From: June Grinstead [REDACTED]
Sent: 13 November 2015 14:12
To: Anita Gardner; Paul Mitchell
Subject: Re: WA/60/15/HH - 6 Nash Way

Location Map & Block Plan

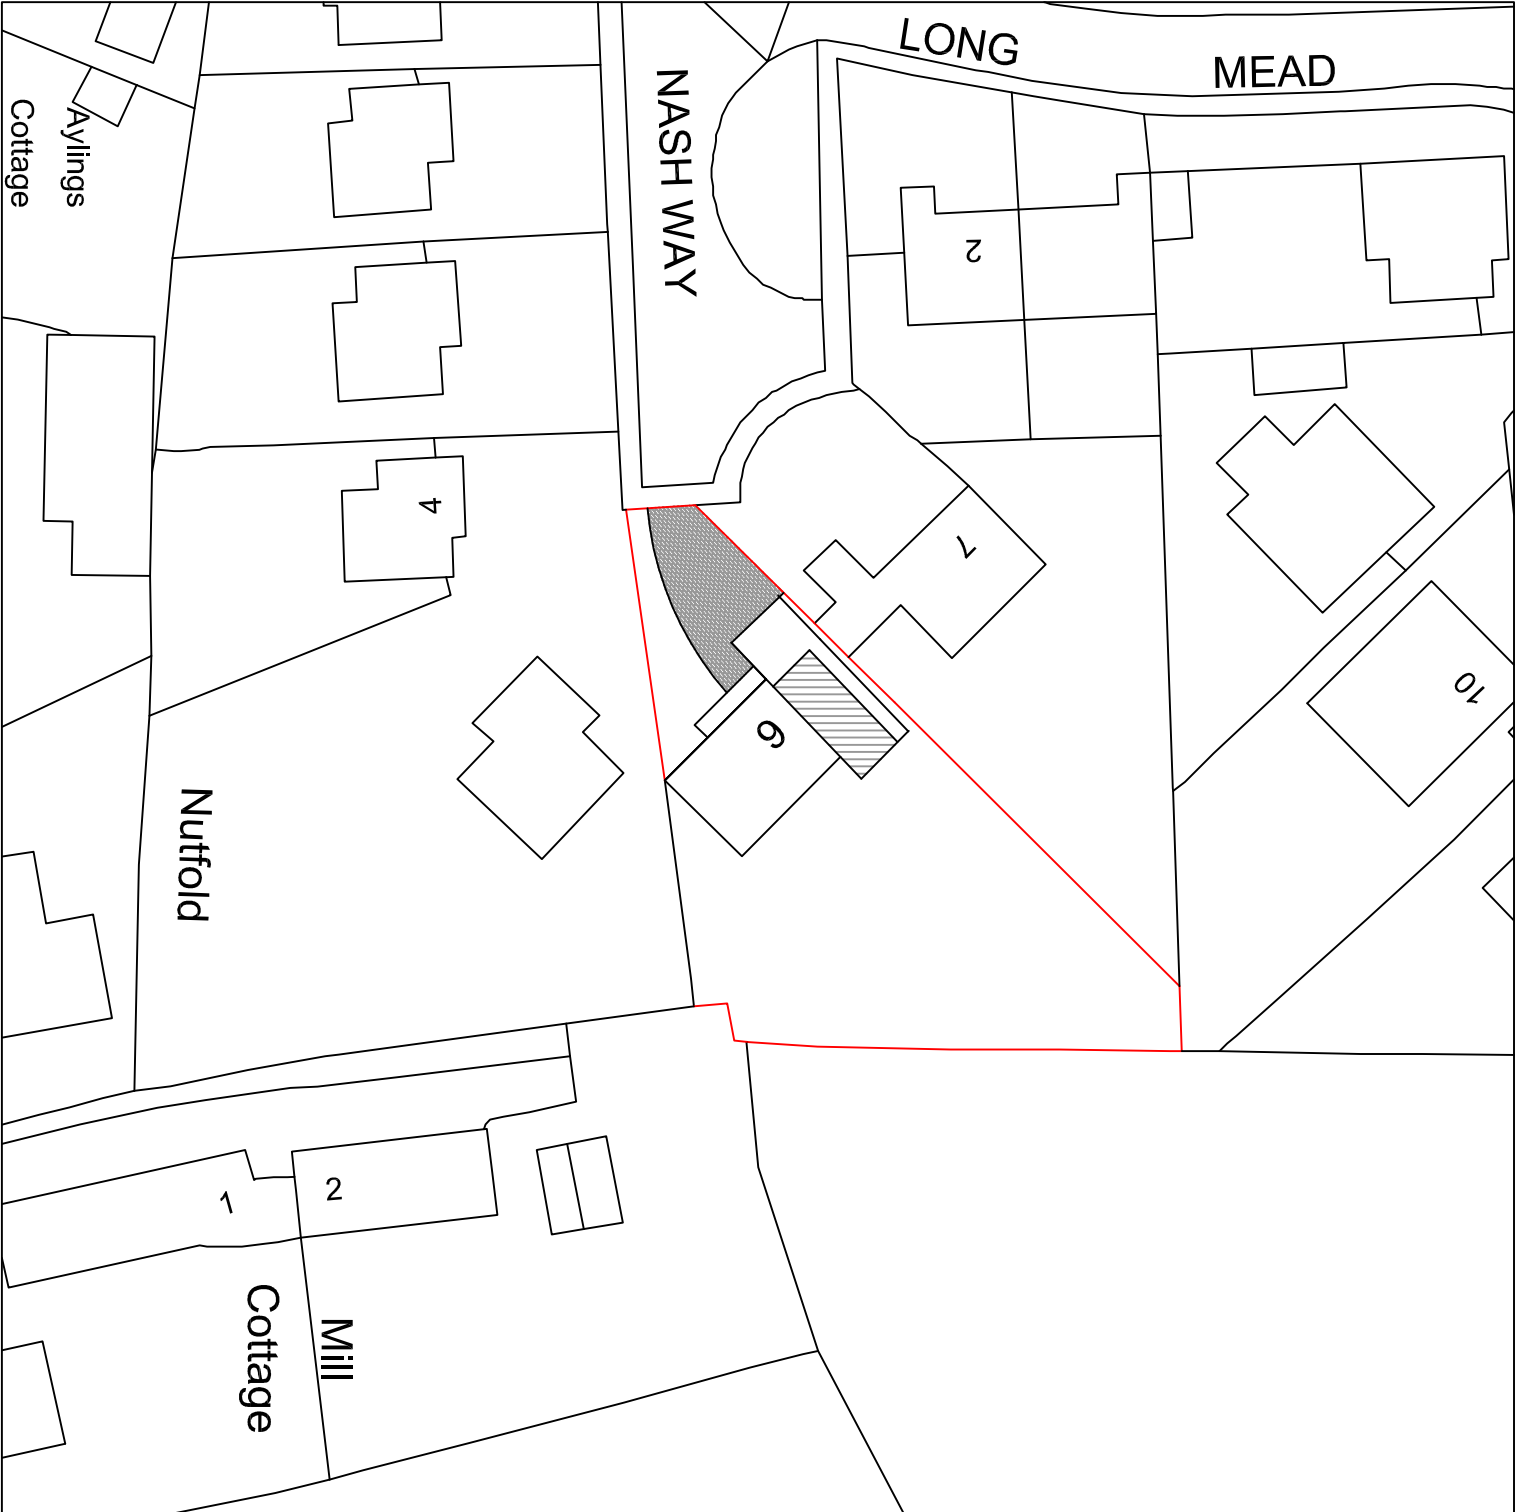
The submitted plans have now been substituted. I note that the 1:500 block plan is incorrect. The hatched area does not correspond with the amended proposed extension and the existing garage/kitchen appears to extend too far to the rear . Please can you let me have a revised plan ASAP

The applicant has just pointed out that the block plan is incorrect. I showed he ground floor existing side extension too be the same length as the proposed first floor, please find updated block plans attached.

## Proposed Elevations

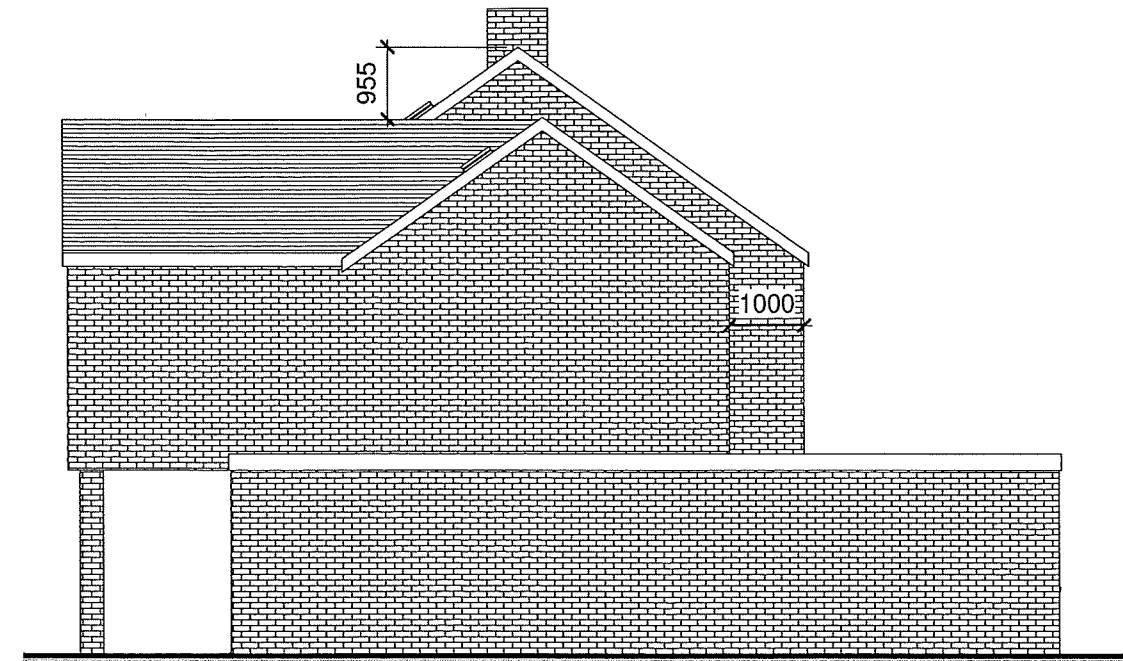
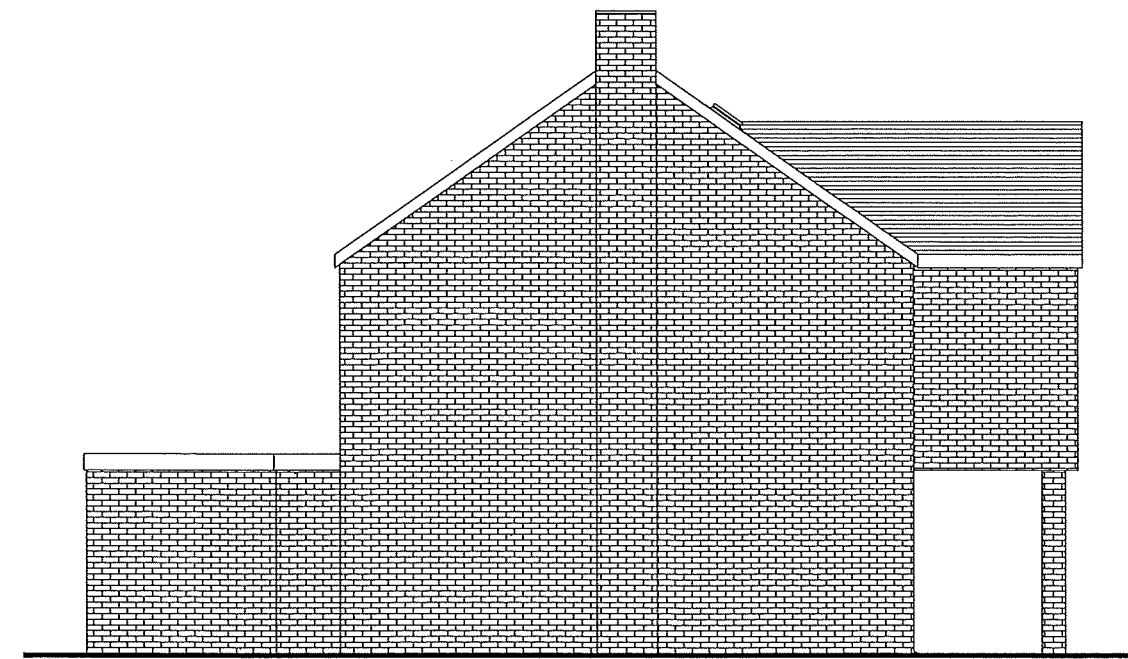
I have discussed the revised plans with my Team Leader. The reduction in ridge height and offset do not go far enough to make the application acceptable. The extension still does not appear subservient and requires further reduction in its overall size. I would suggest that the ridge height is set at least 1.5m below the current ridge line and that it is set back at least a metre from the front elevation. It would also benefit from a 1m gap being provided from the roof to the boundary and a reduction in depth of the extension. The amount of proposed accommodation will need to be rationalised.

My initial comments are that I do still have concerns over the size of the extension, I don't consider the ridge height has been reduced sufficiently or that it has been set back an acceptable amount from the front elevation but I haven't yet had the opportunity to discuss the current plans with my Team Leader before I come back to you. I won't refuse the application without allowing you the opportunity to amend the scheme. I should be able to let you have my views on the extension by the end of the week.

Please find attached the revised plans. The front wall has been set back 1m and the front roof has been changed to match the ridge height of the rear roof, this lowers the ridge to nearly 1m. I think this would be a better option than changing the pitch or adding a flat roof. With regards to the verge overhang, the existing ground floor side wall is already at least 250mm away from the boundary line therefore I haven't moved it in on the side.
